Case Officer: Jessica Hill
Direct Dial: 01730 234219
Fax no: 01730 260288
Our Ref: 40121/999
Your ref:
Date: 06 July 2017
email: Jessica.Hill@easthants.gov.uk

Re: Osborne House West, 2 Portsmouth Road, Liphook, GU30 7AA

Jessica Hill
Conservation Officer

Plans proposed Scale 1:100

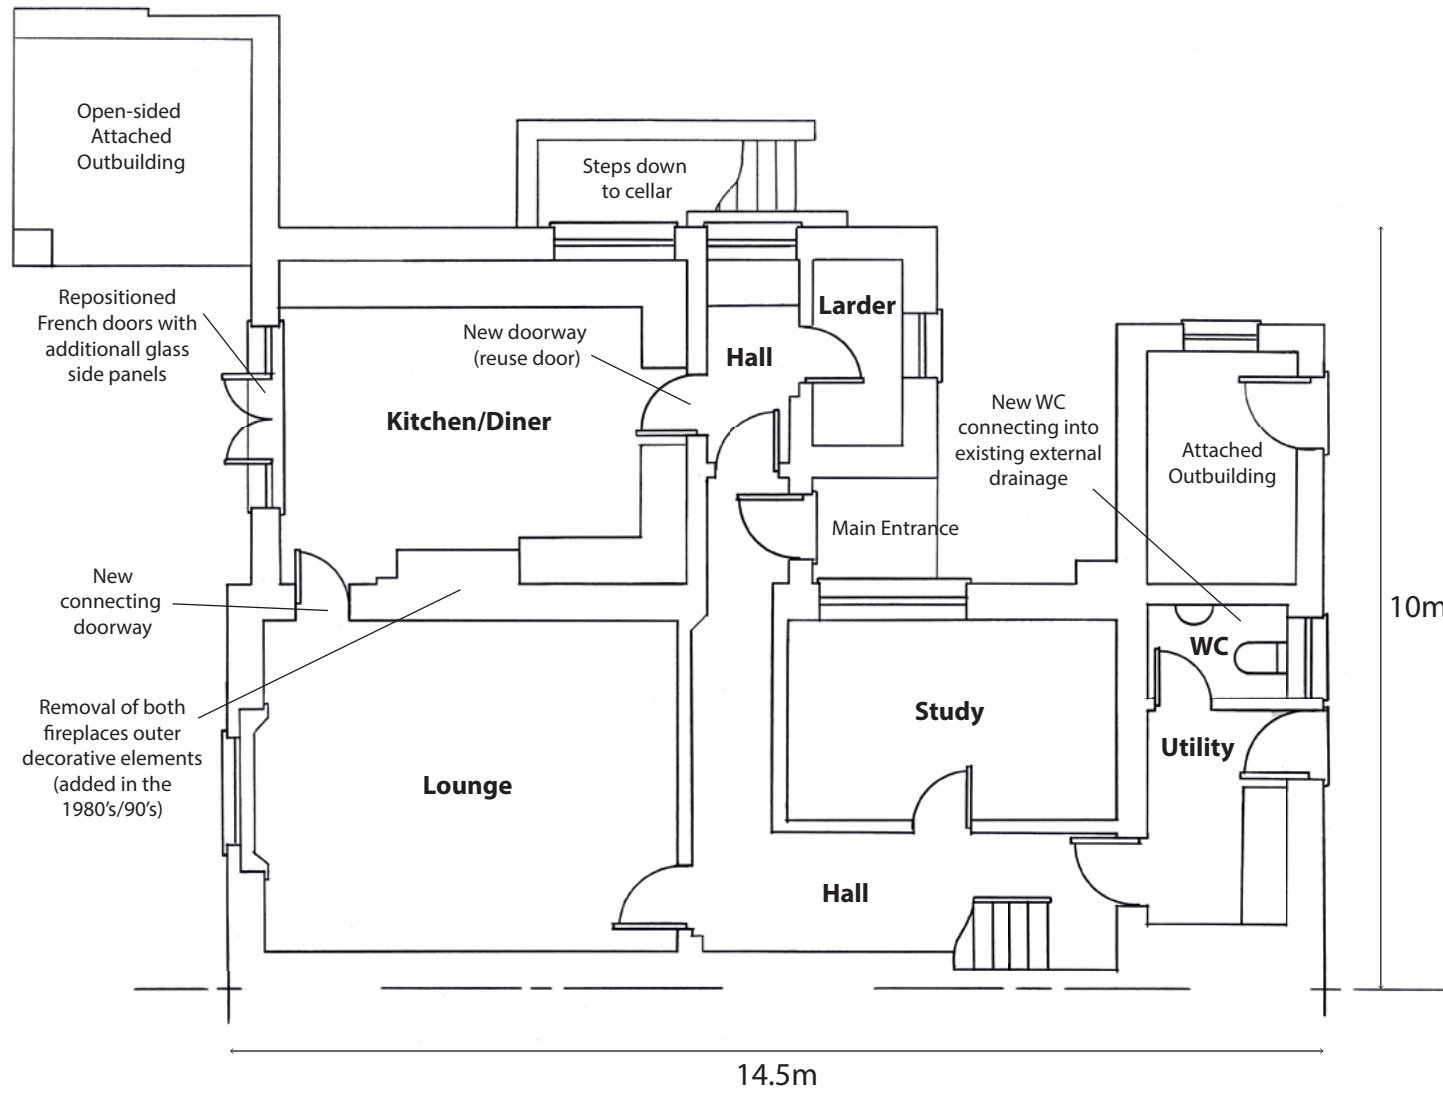
The proposal was to move the kitchen into what is currently the dining room and the creation of a doorway between the proposed kitchen and the drawing room.

The moving of the kitchen in itself is not an issue, however obtaining the necessary water supply many require further investigation as to how this will be achieved. One suggestion is to tap into the water supply to the cloakroom taking it across the external wall at floor level which could be a possibility. The key is minimising any disruption to the fabric and fittings of the building as they currently stand. Pipe work could be boxed in over the skirting to achieve this. And the layout of the kitchen should seek to again minimise damage and disturbance to any historic fabric.

The creation of a new doorway whilst not ideal could be achieved if it could be below the picture rail level so that the rail can be maintained along with the cornice. This work would require Listed Building Consent. The usual target time for the turn around of Listed Building Consent is six weeks from validation of the application. Applications can be made on line or forms can be downloaded and sent in.
